**From:** Anita Gardner [<mailto:Anita.Gardner@arun.gov.uk>]  
**Sent:** 16 July 2014 14:17  
**To:** Derek Bowerman  
**Subject:** AB/72/14/HH and AB/73/14/L - 43 King Street, Arundel

**Our Ref:** AB/72/14/HH

DRG. No.	13151-02 A
SCALE	1:50
DATE	November 2013
DRAWN	SR
CHECKED

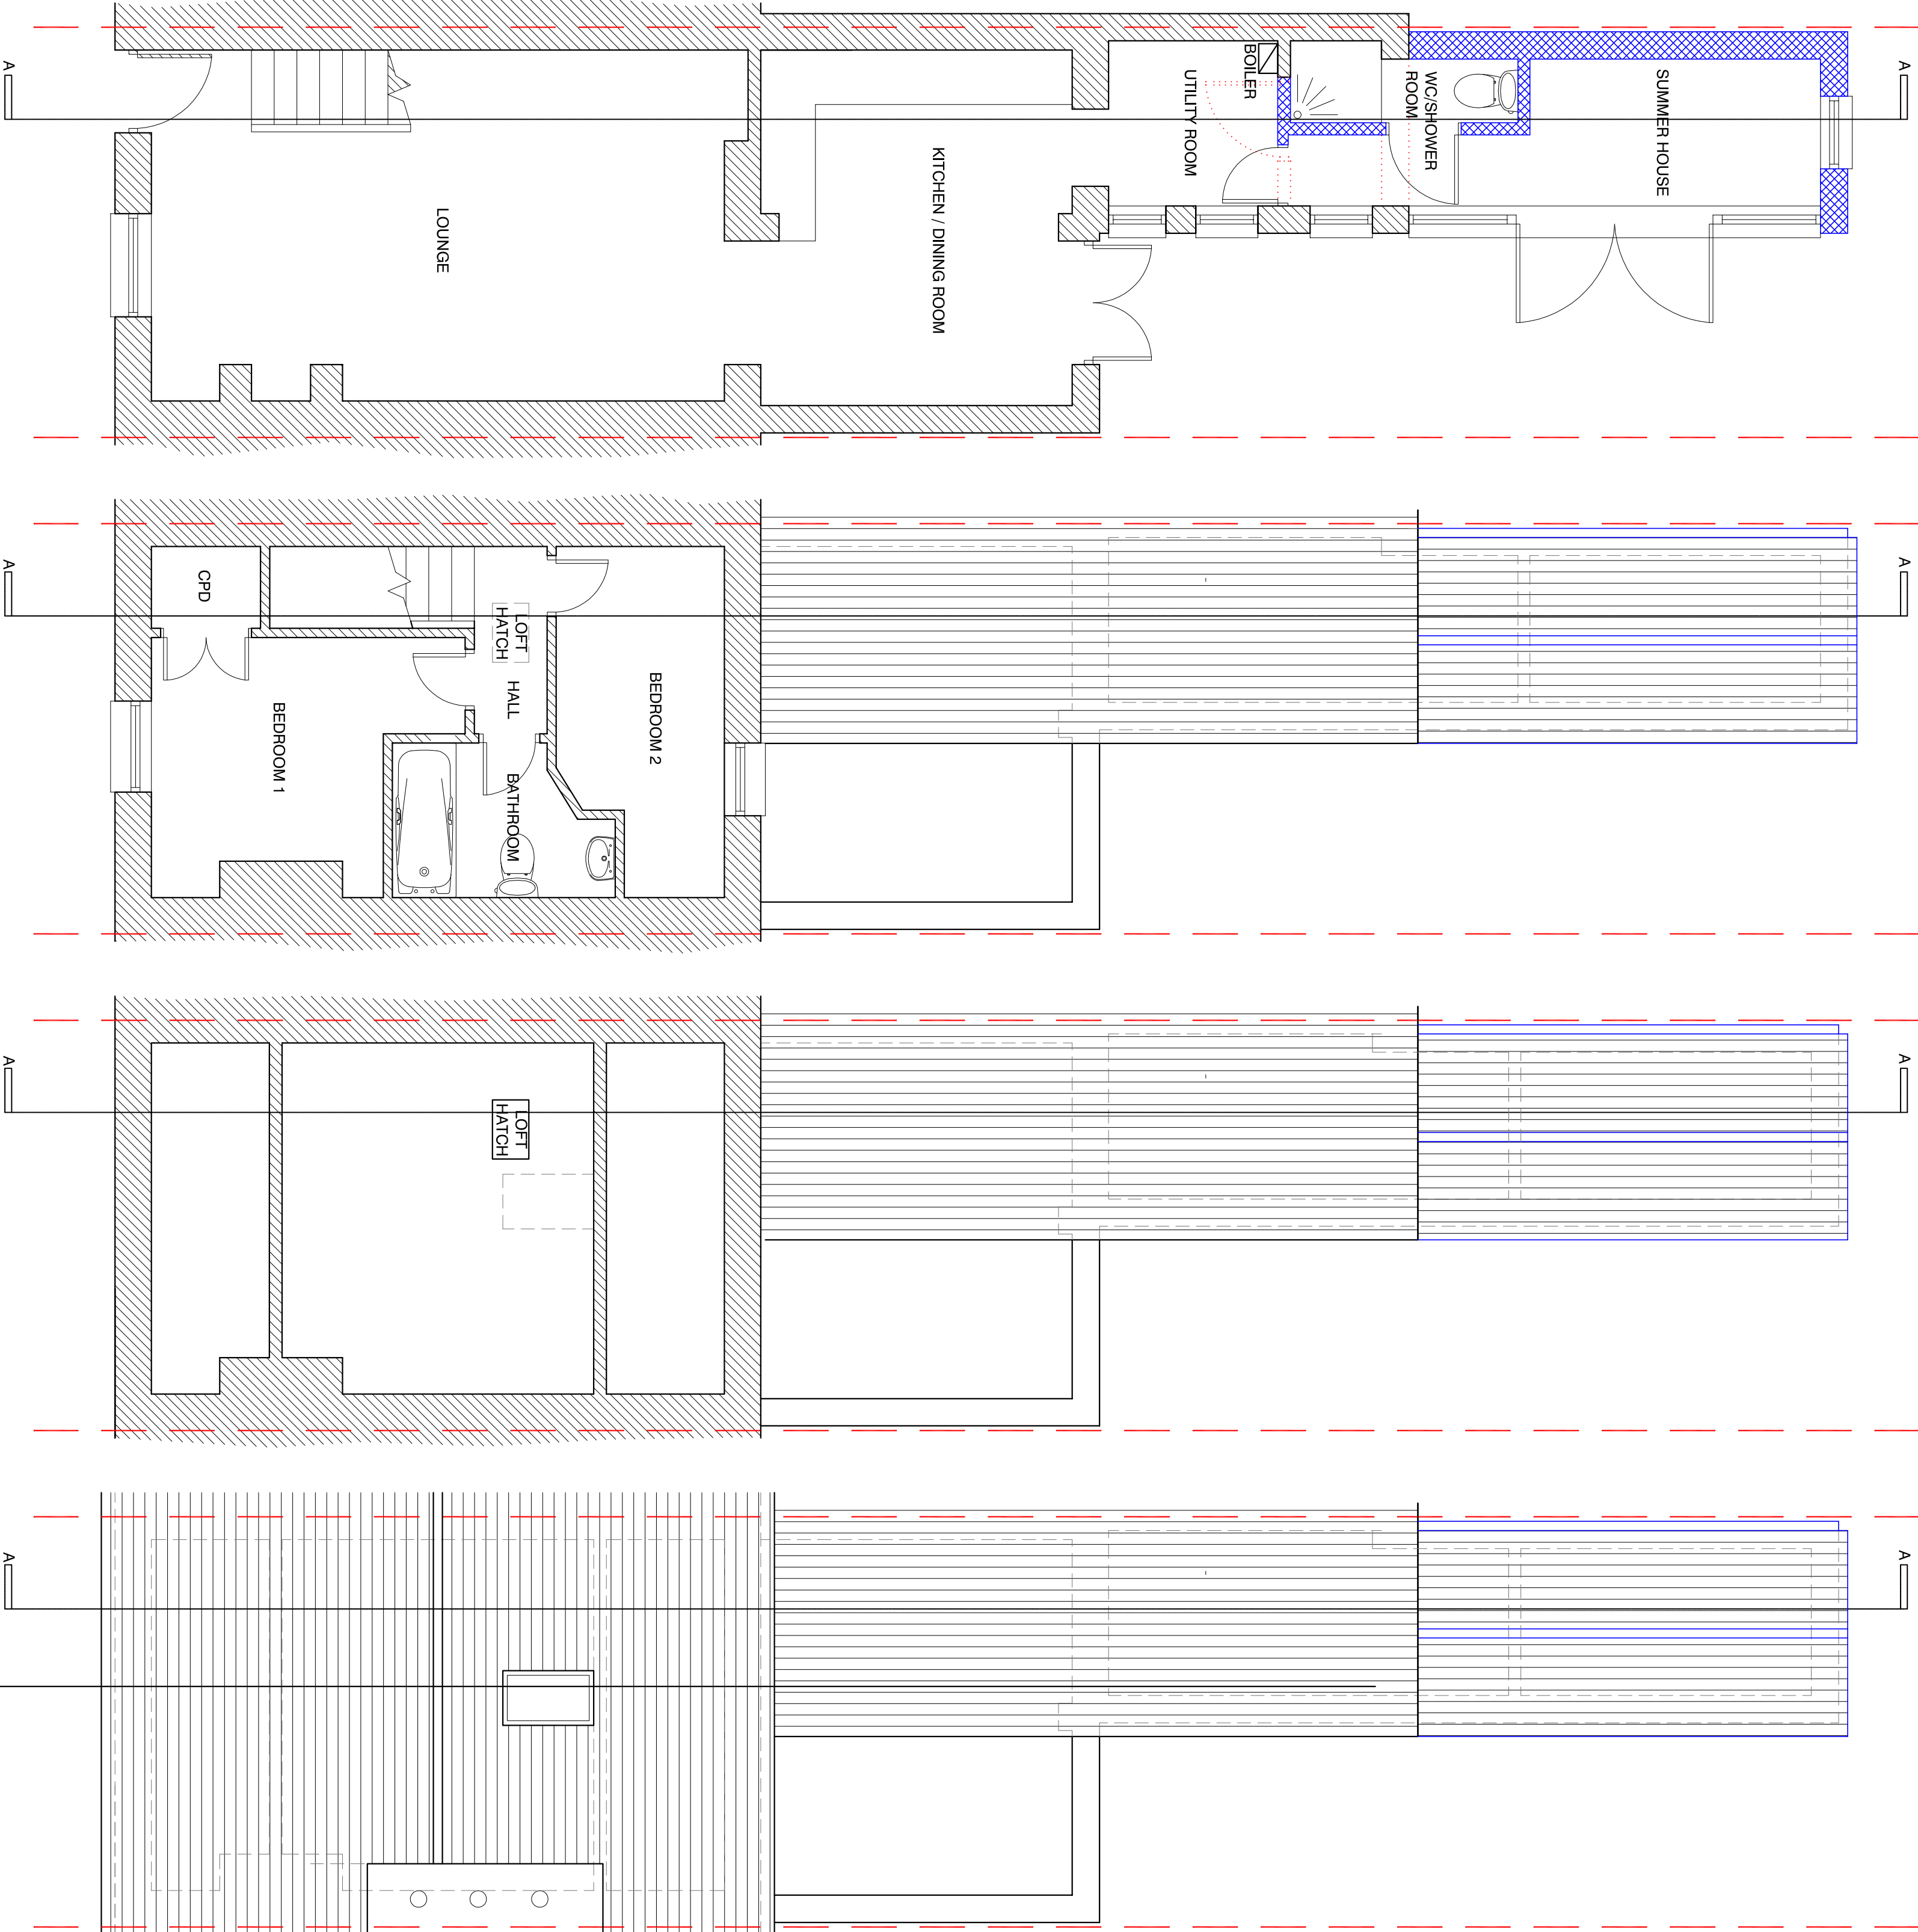
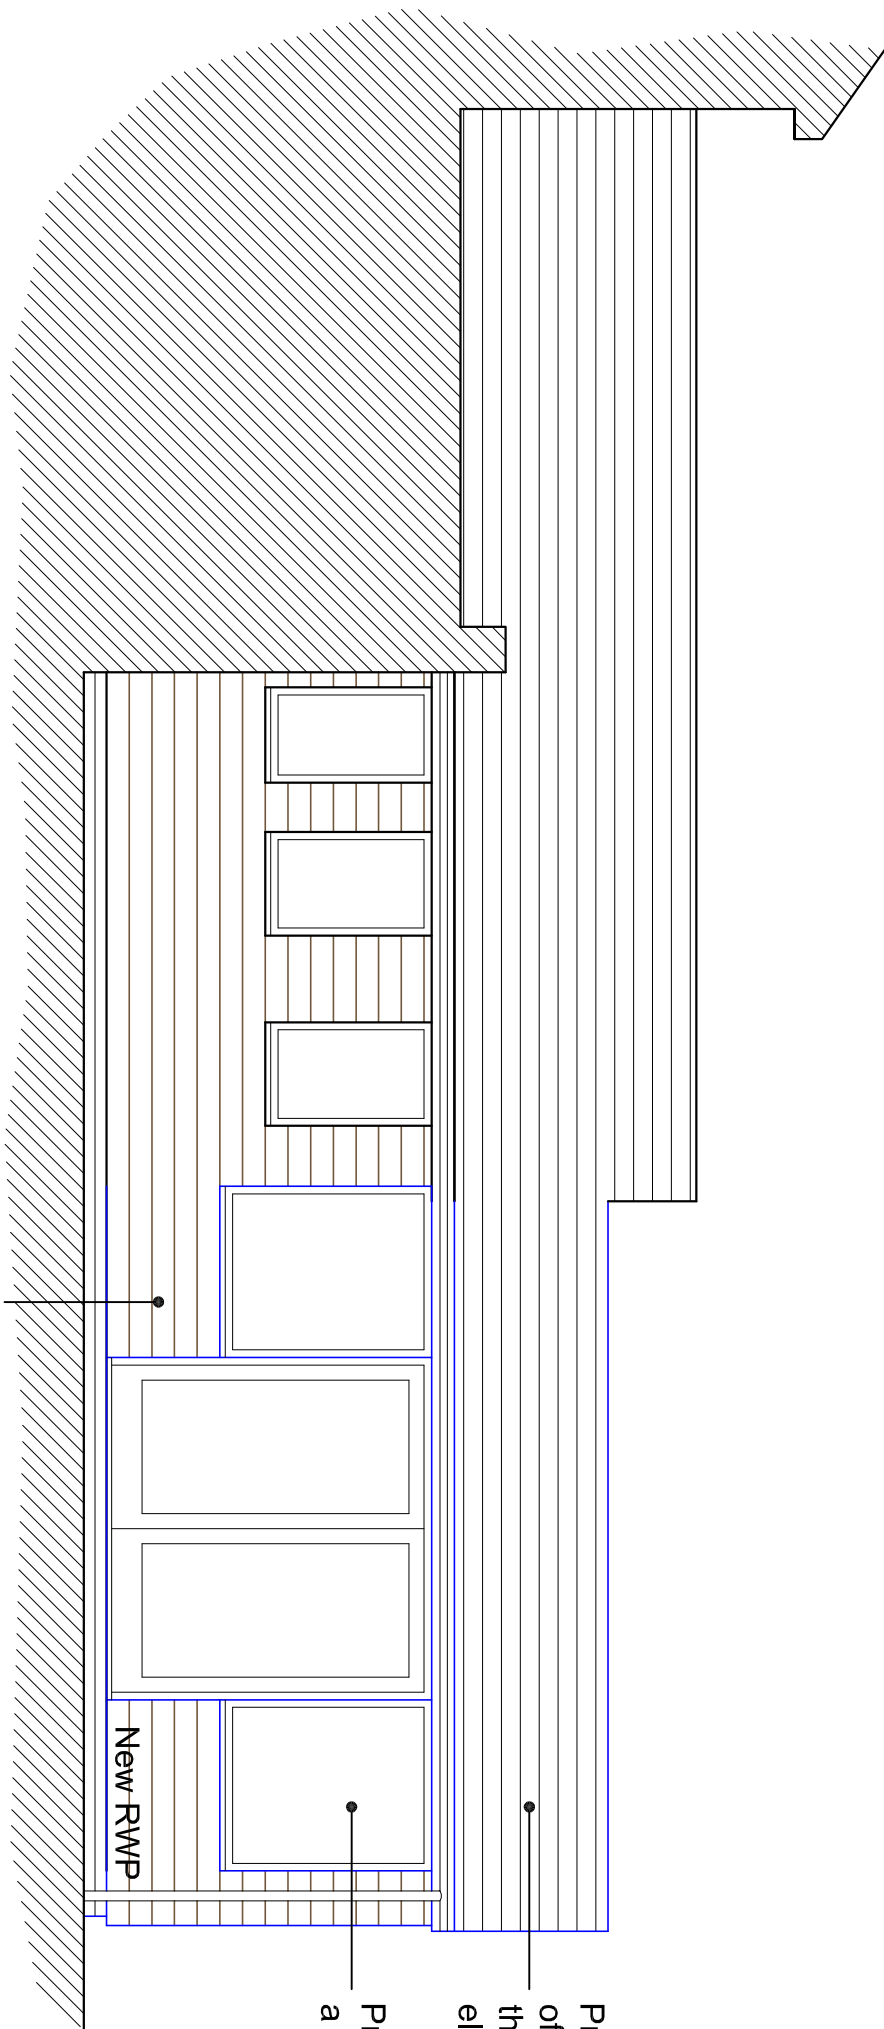
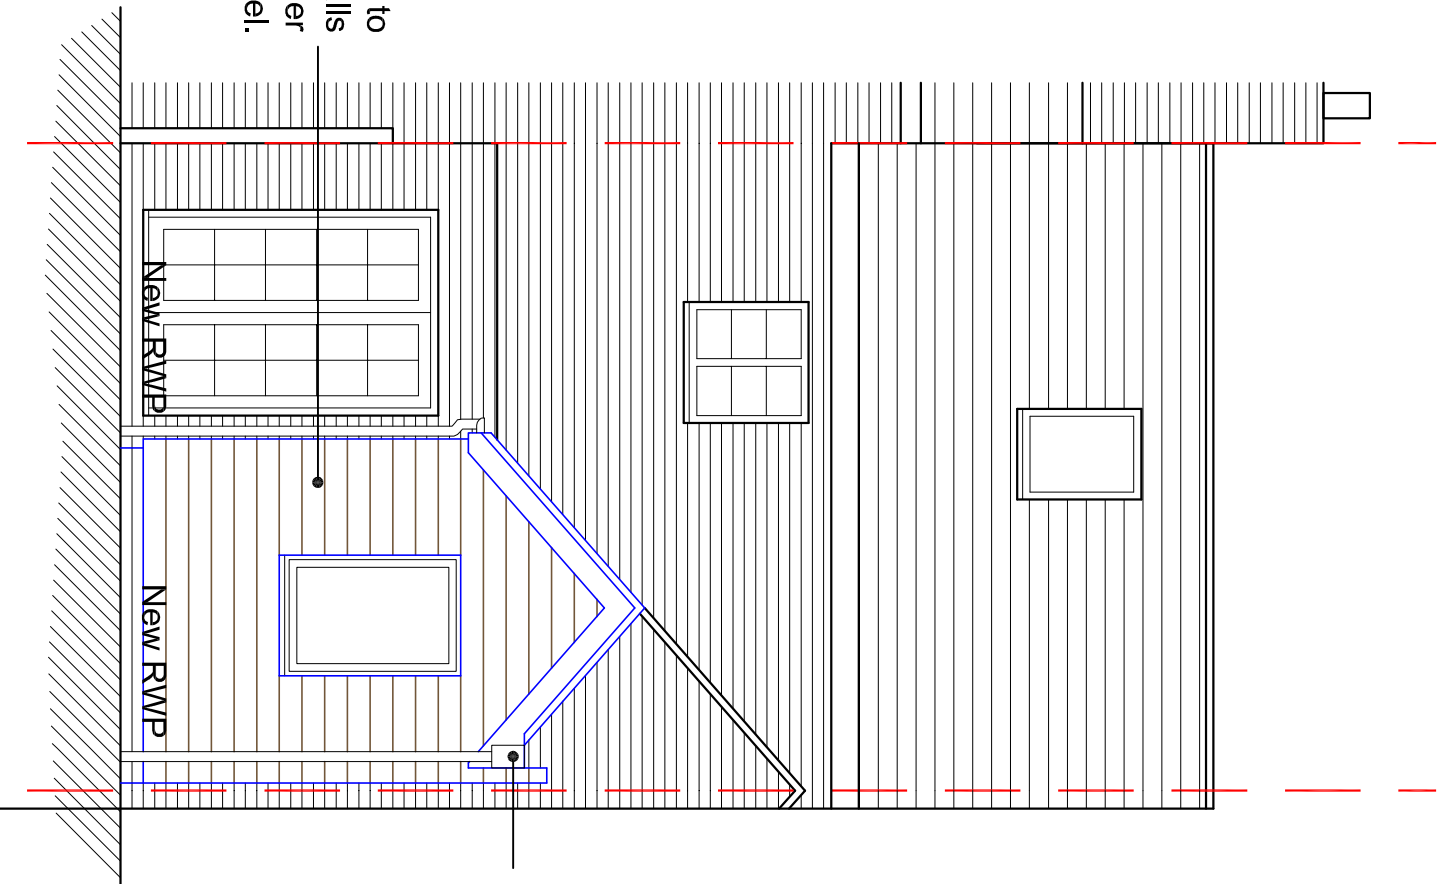
I have visited the above site today and viewed the proposal from the neighbour's garden. The submitted elevations are incorrect. As you can see from the attached photograph the existing roofs to the rear of the existing dwelling are not the same height. The roof of the original outbuilding is also higher than indicated, at least eaves height of the original dwelling or above. Given the inaccuracies of the existing elevation plans it is not easy to accurately determine the height of the proposed roof.

Without prejudice, please provide accurate dimensioned elevation plans for consideration within the next 7 days.
